A303 Amesbury to Berwick Down

8.6 Statement of Common Ground – Natural England

STATEMENT OF COMMON GROUND – Natural England

Version	Date	Status of Version
Rev 0	03.05.2019	Deadline 2 Issue

NOTE 5 : TO BE READ IN CONJUNCTION WITH THE ENVIRONMENTAL MITIGATION SCHEDULE PRESENTED AT APPENDIX 2.1 OF THE ENVIRONMENTAL STATEMENT

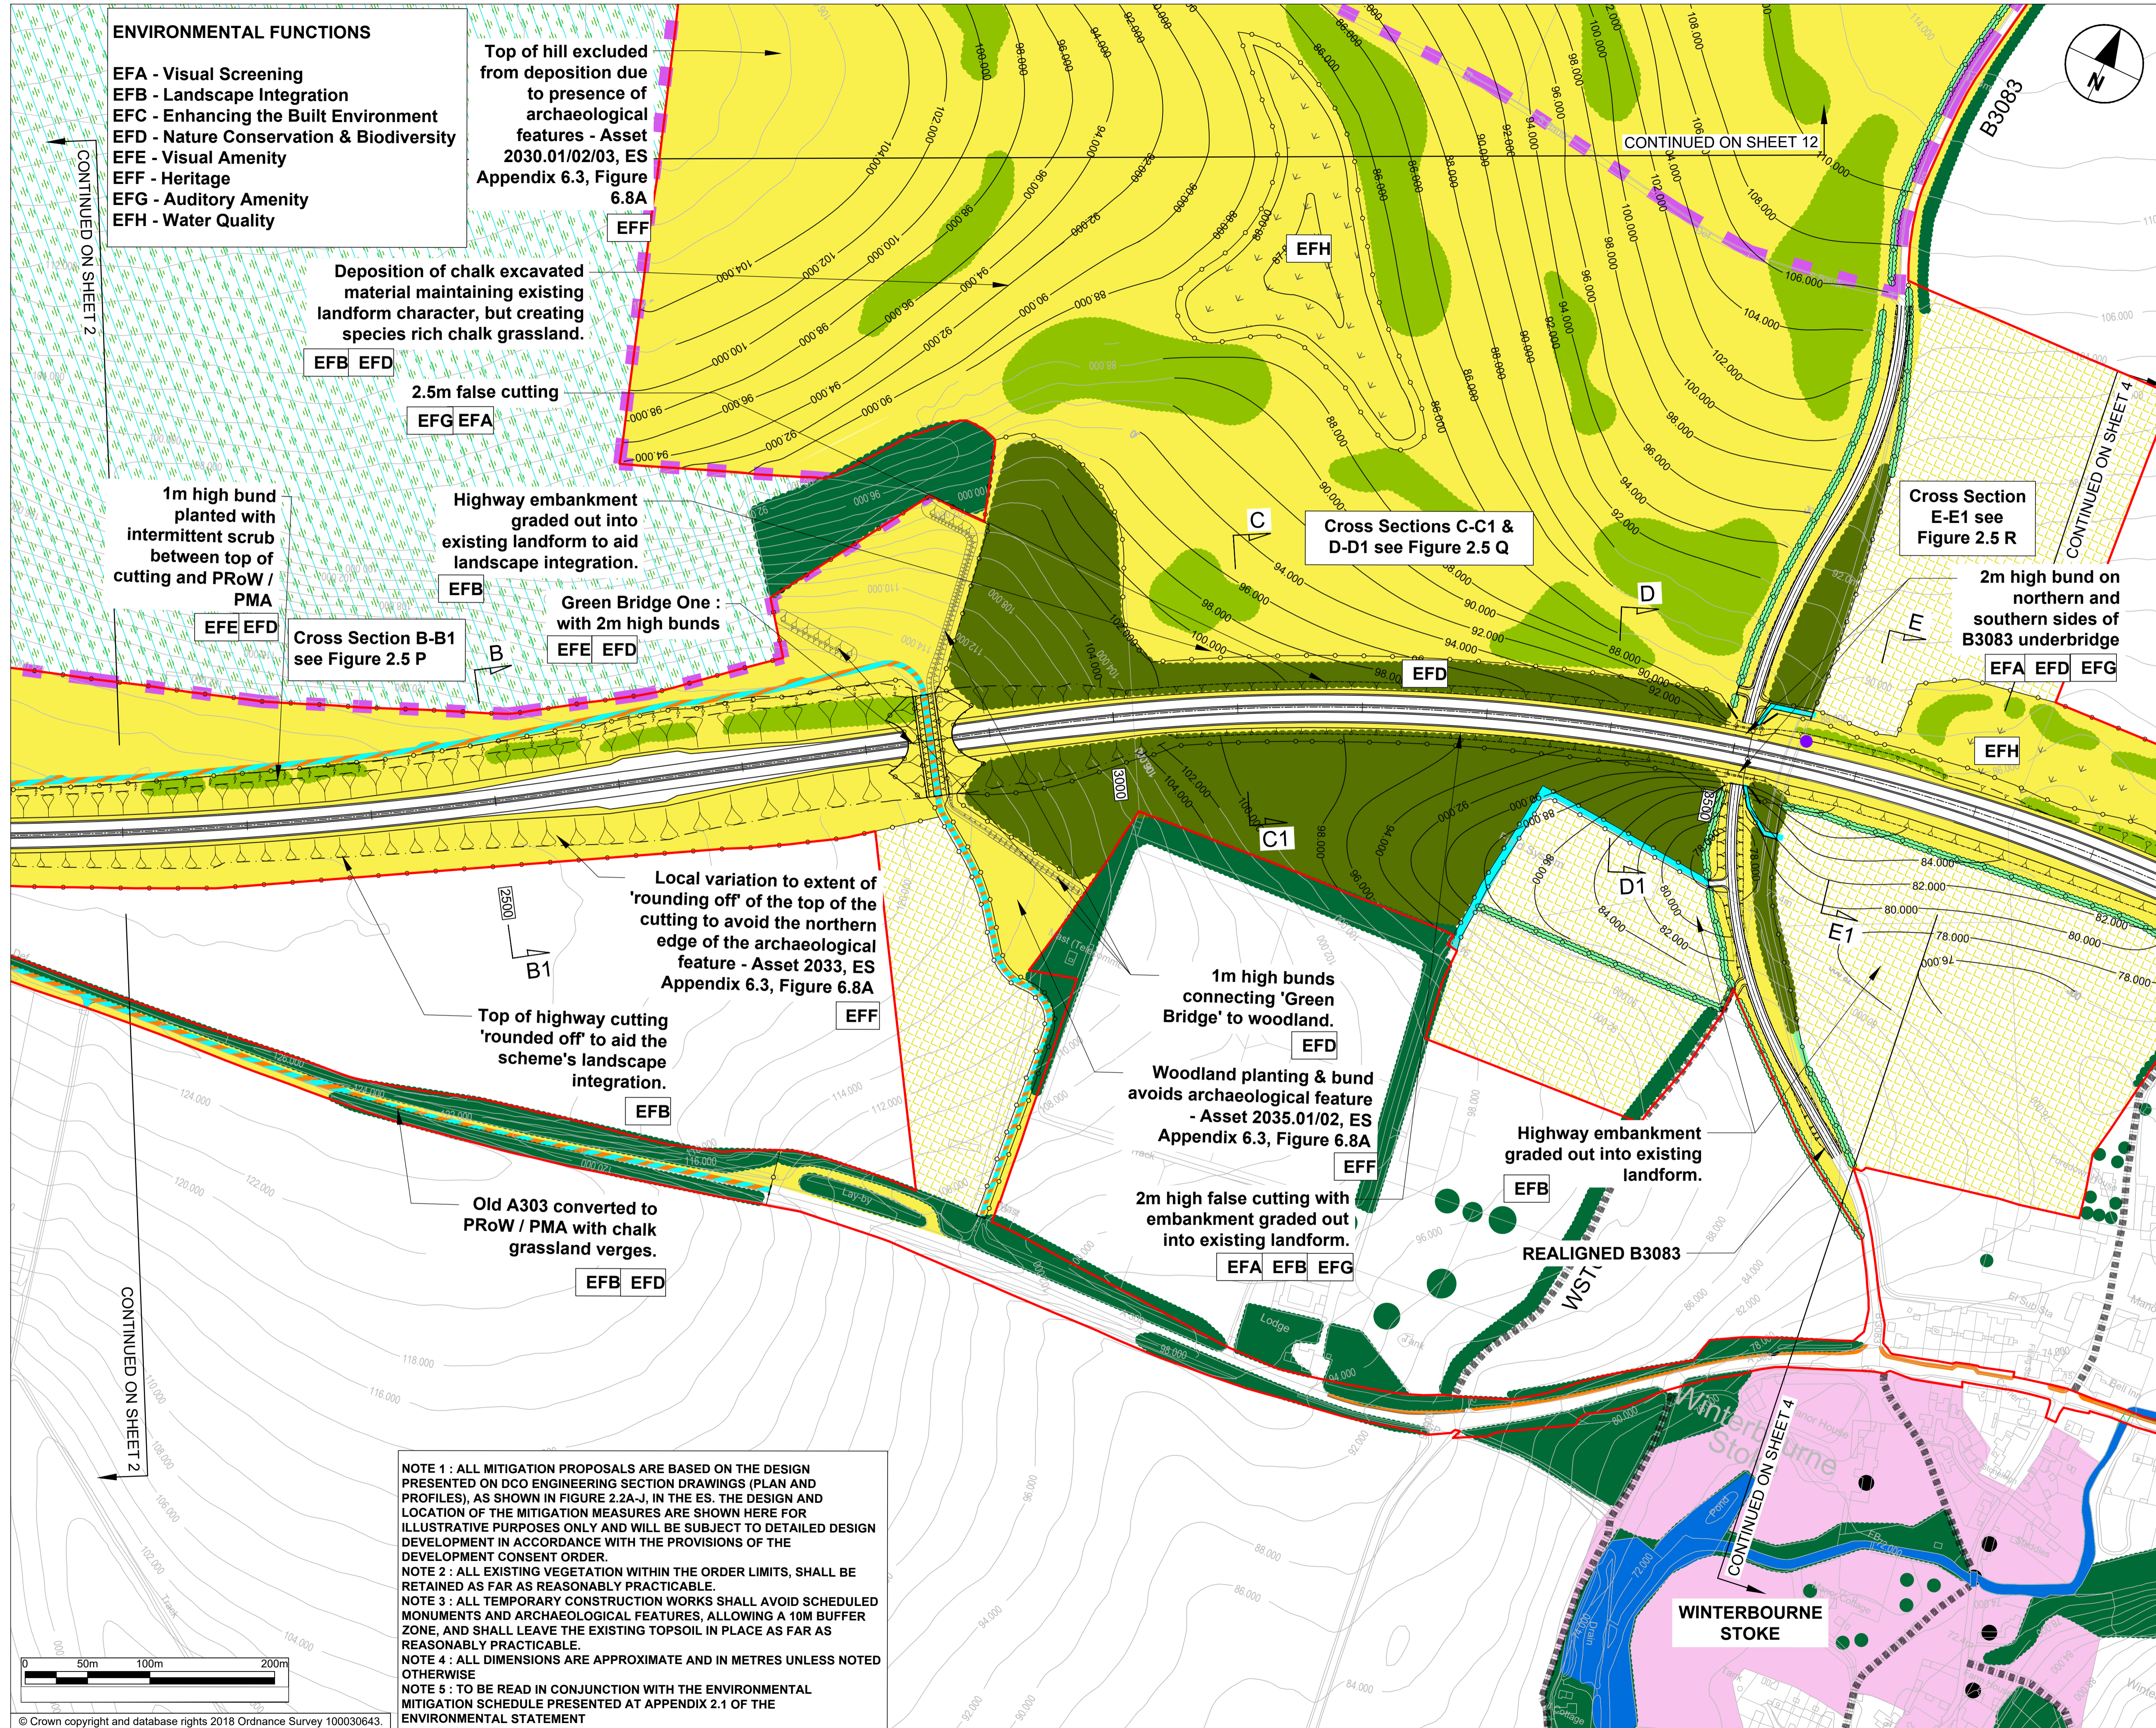
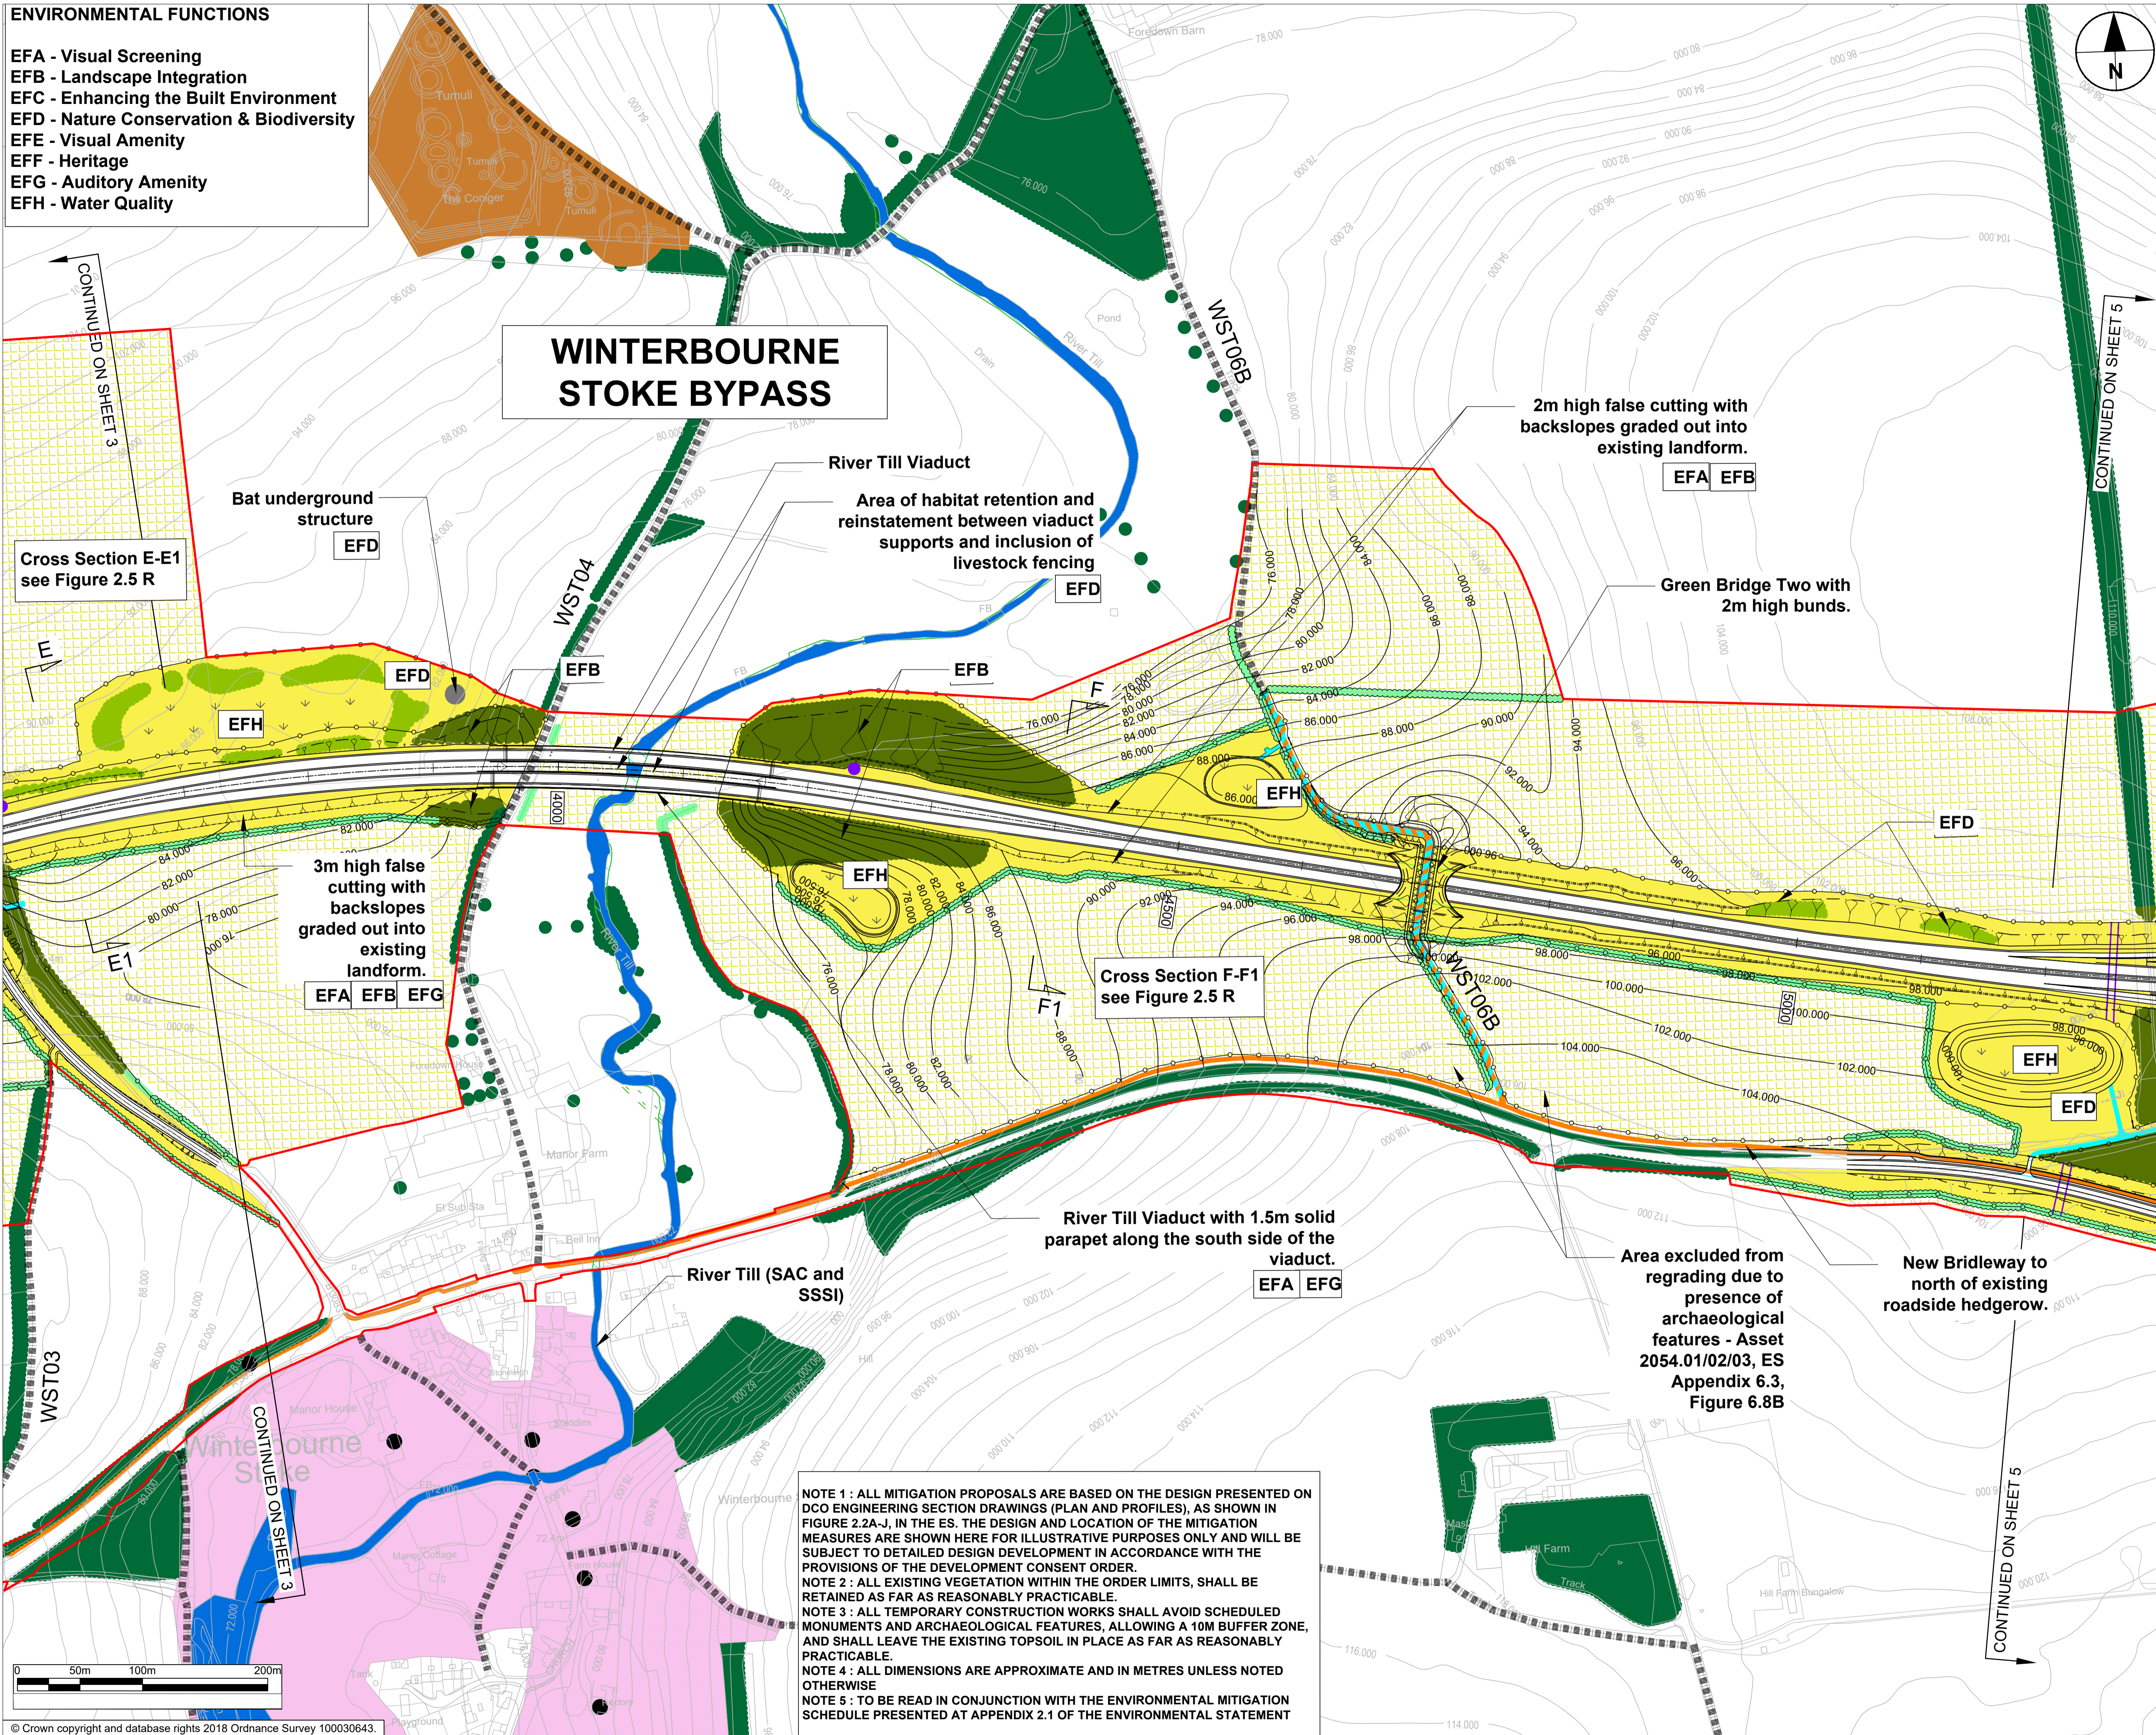
3.7	Environmental Statement Chapter 8 Biodiversity [APP-046] and Figure 2.5 Environmental Masterplan [APP-059]	Table 8.14	Embedded mitigation Shrub planting	<p>The Environmental Masterplan includes numerous areas of shrub planting. These are liable to become management liabilities requiring expenditure on scrub control much greater than if left unplanted and likely to be detrimental in the long term to biodiversity. We are not clear what the purpose of planting these areas and advise each is only retained if there is a good reason to do so.</p>	<p>Discrete areas of shrubs have been included in the scheme as shown indicatively in the Environmental Masterplan [APP-059] to provide a landscape link, for screening purposes and to provide a mosaic of habitats.</p> <p>The shrubbed areas will be designed taking into account the need to avoid future management issues associated with rapidly expanding scrub. The principles of creation and management of these shrubbed areas are set out in the</p>	Agreed

3.8	Environmental Statement Chapter 8 Biodiversity [APP-046] and Figure 2.5 Environmental Masterplan [APP-059]	Table 8.14	Embedded mitigation - Woodland creation	Whilst early successional chalk habitats are the primary ecological aspiration for the scheme, the modest levels of woodland creation provide useful landscaping and are not without their ecological benefits in terms of habitat diversity in general and key bat species.	Agreed between Natural England and Highways England 11 January 2019	Agreed

from Winterbourne Stoke via Green Bridge 1 is especially welcome in this context.		
3.10	Environmental Statement Chapter 8 Biodiversity [APP-046] and Figure 2.5 Environmental Masterplan [APP-059]	Table 8.14	Embedded mitigation Hedgerow creation	Hedges should be used to separate arable land from species rich chalk grassland, as this will help reduce spray drift onto the grassland and provide a valuable habitat in its own right. These benefits will outweigh the negative effect of encouraging the spread of scrub onto the species rich chalk grassland, provided the species mix for the hedge does not include rapidly spreading species such as dogwood or blackthorn. These should be excluded from the planting mix. On this basis, it would appear that there are additional locations where hedgerow planting may be beneficial.	All hedgerows within the DCO boundary to be retained will be managed during the construction phase. This is secured by the OEMP (MW-G28) [APP-187], which is required to be implemented pursuant to paragraph 4 of schedule 2 to the draft DCO. Hedgerows have been included in the scheme as shown indicatively in the Environmental Masterplan [APP-059] to provide a landscape link, for screening purposes and as suitable boundaries.	Agreed

Outline Landscape and Ecology Management Plan ('OLEMP') [APP-267], details of which, are secured as part of the landscaping scheme pursuant to Requirement 8 (Implementation and maintenance of landscaping) under Schedule 2 of the DCO [APP-020].
